**POST- ISSUE SPECIFIC HEARINGS  
SUBMISSION**

**DEADLINE 3**

**IP Ref: 20018303**

**A63 Castle Street Improvement Scheme  
HULL  
TR010016**

5.1.1 Replace ES Volume 2 Figure 15.2 Proposed non-motorised users facilities and closure for the Scheme (APP-040) with the revised Figure 15.2 as below. Changes are as follows:

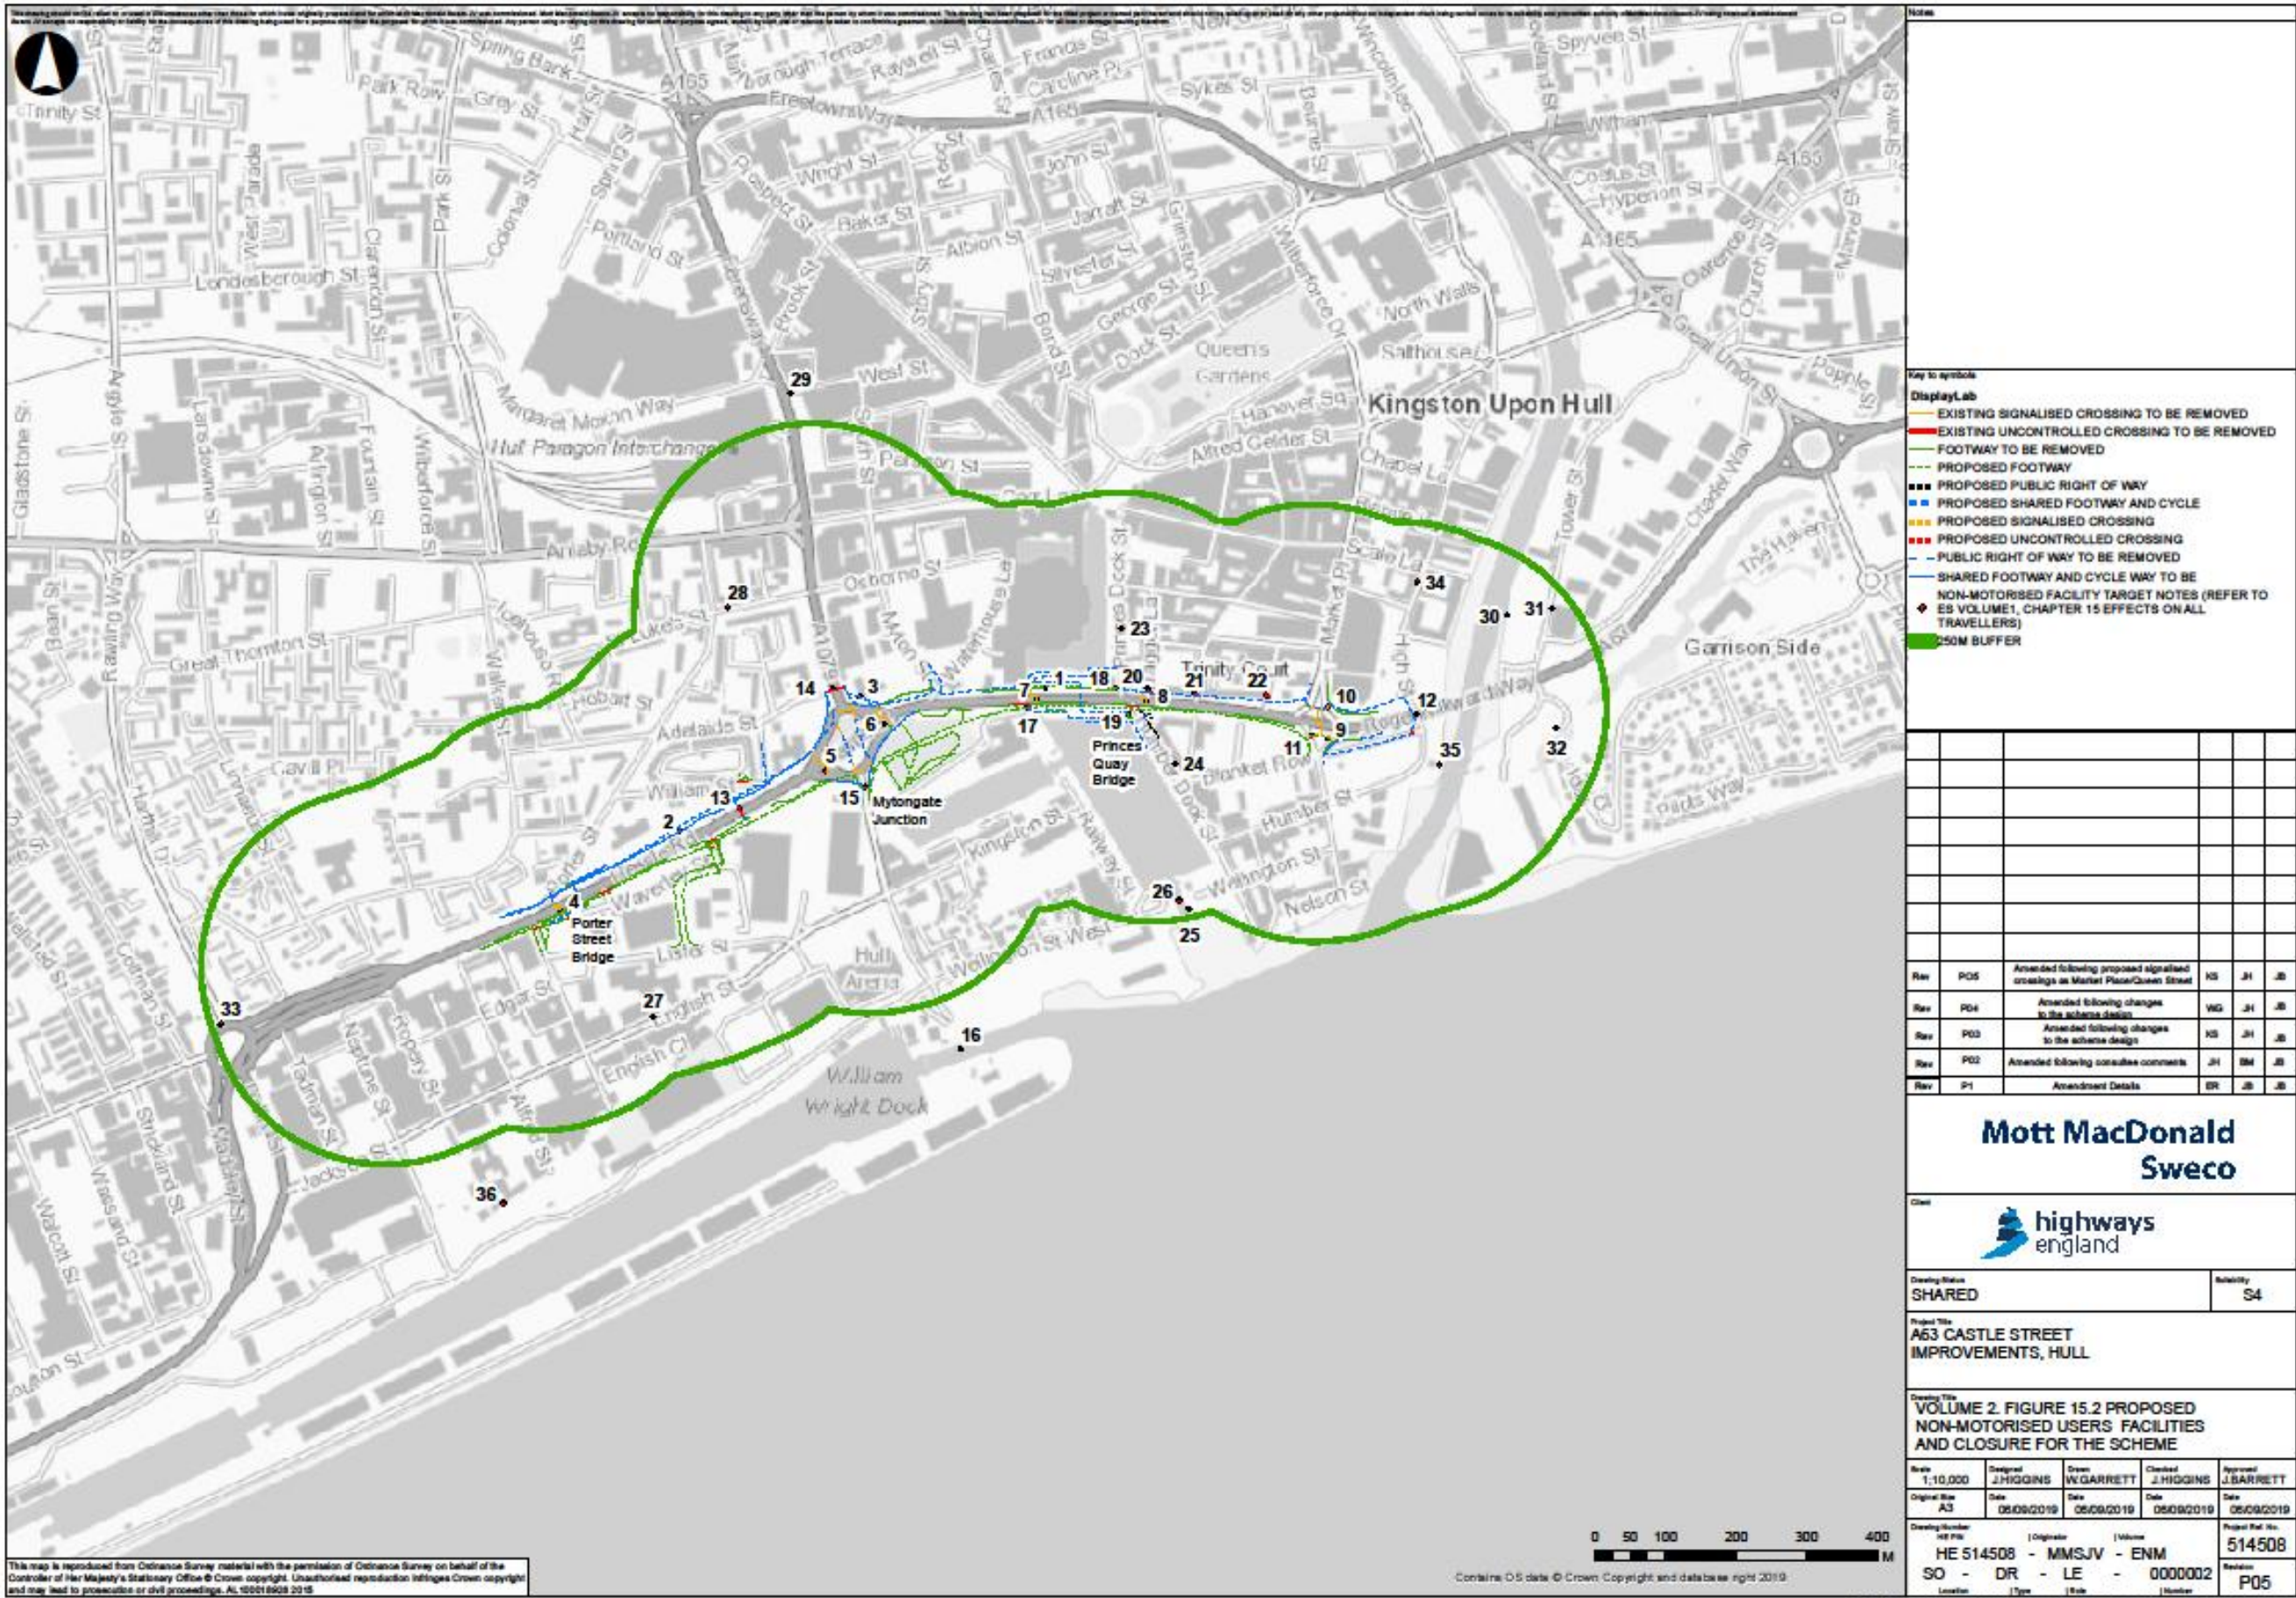
HCC seek further information to demonstrate the proposals with regards to access, routing and connections for cycling. As raised at the Issue Specific hearing on Traffic and Movement, at present the Non Motorised User Route Plans Sheets 3 and 6 do not show cycling facilities on the south side of the A63 (between St James Street and Queen Street). Nor do they show such facilities along the northern side of the A63 in the vicinity of Princes Quay Bridge, between the Earl de Grey and Princes Dock Street.

As currently shown it is possible to cycle to both pedestrian / cycle bridges and the Mytongate Bridge on the north side of the A63 and cross to the south side but there is no continuous onward connection to the wider cycle network and emerging proposals. There is no indication of how the scheme connects with the existing cycle network on the south side and no indication of where cyclists should go or how they would reach the southern ramps of the bridges.

The four signalised pedestrian crossings at the Market Place and Queen Street junctions are proposed within the submitted scheme to be replaced with uncontrolled crossing facilities. The crossings are located on the diverge and merge slips from/to the A63 carriageway; pedestrians are therefore likely to encounter relatively fast moving vehicles at these locations, particularly those across the A63 entry slips where vehicles will be accelerating to join the mainline. The reduction in the level of provision at these locations increases the likelihood of drivers unexpectedly encountering pedestrians in the carriageway, and associated collisions. The Council request amendments to ensure compliance with the recommendation identified in the Stage 1 Road Safety Audit (Problem Location 56) which identified that the east-west crossings for pedestrians and cyclists at both Market Place and Queen Street should be signalised as per the existing level of provision. This is particularly important in the context of the fact that the demand for movement across both side roads is predicted to increase, especially in connection with the use of the High Street Underpass as a consequence of the proposed removal of the north –south controlled crossing at Market Place.
